WEST SUSSEX COUNTY COUNCIL CONSULTATION

TO:	Arun District Council FAO: Maria Tomolova
FROM:	WSCC - Highways Authority
DATE:	16 March 2022
LOCATION:	Rustington Convalescent Home Sea Road Rustington BN16 2LZ
SUBJECT:	R/39/22/DOC Approval of details reserved by condition imposed under ref R/187/16/PL relating to Condition Nos 4 - materials and finishes of proposed buildings in Phase 2 and 17 - Construction Management Plan.
DATE OF SITE VISIT:	n/a
RECOMMENDATION:	More information
S106 CONTRIBUTION TOTAL:	n/a / £ See below for breakdown.

Discharge of condition 17 - Construction Management Plan

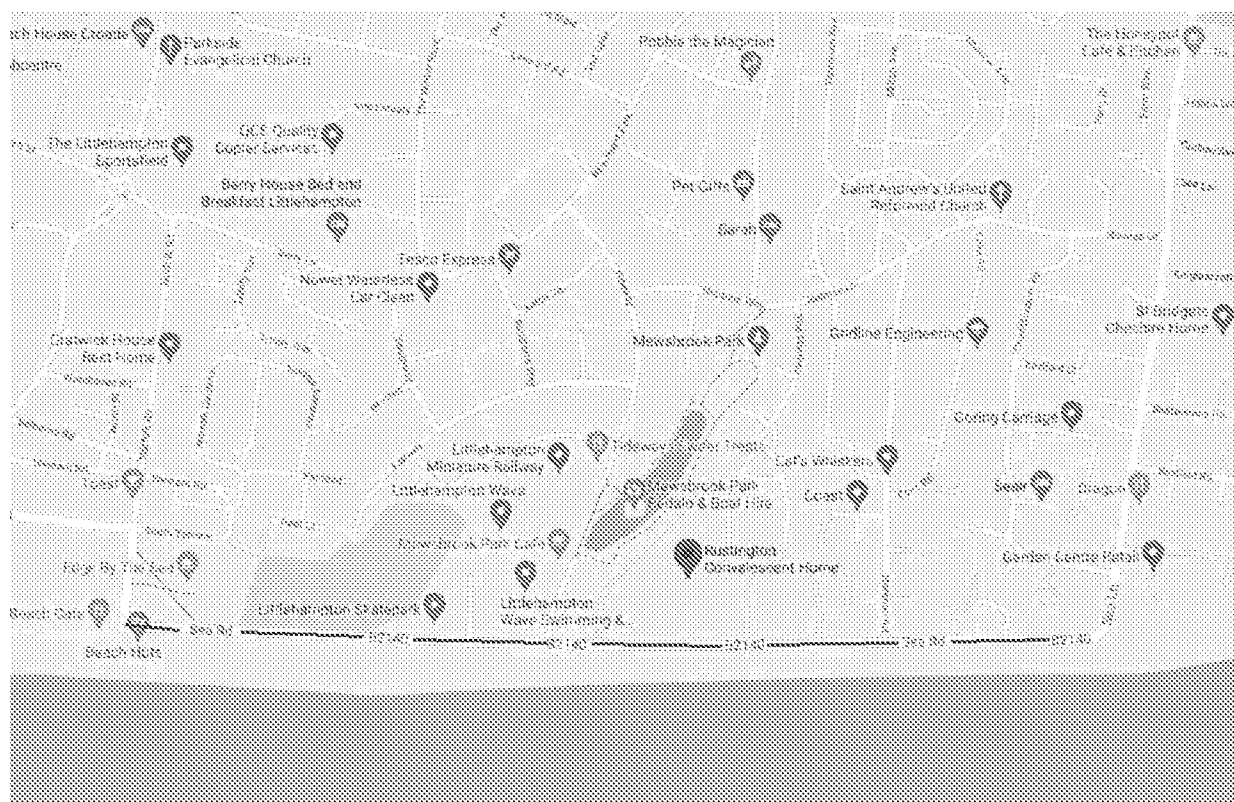
The applicant commits to undertake a road condition survey of the B2140, Sea Road prior to construction. WSCC would advise the applicant to make contact with the Area Highways Manger, Adam Bazely, as WSCC should be present at this walk through.

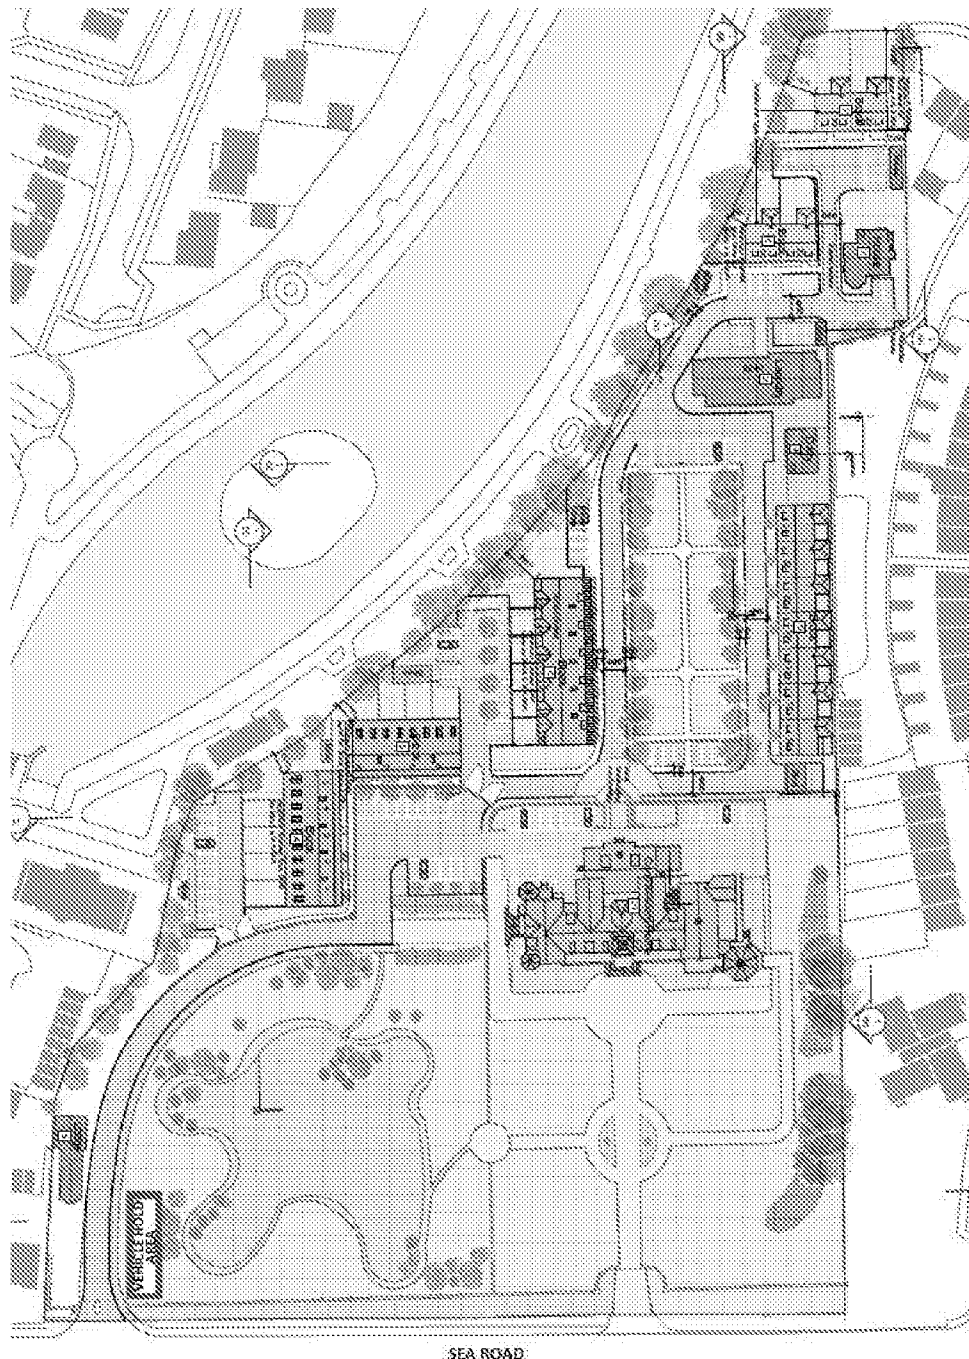
Details regarding the anticipated number, frequency, and types of vehicles used in construction, erection and maintenance of security hoarding has not been provided.
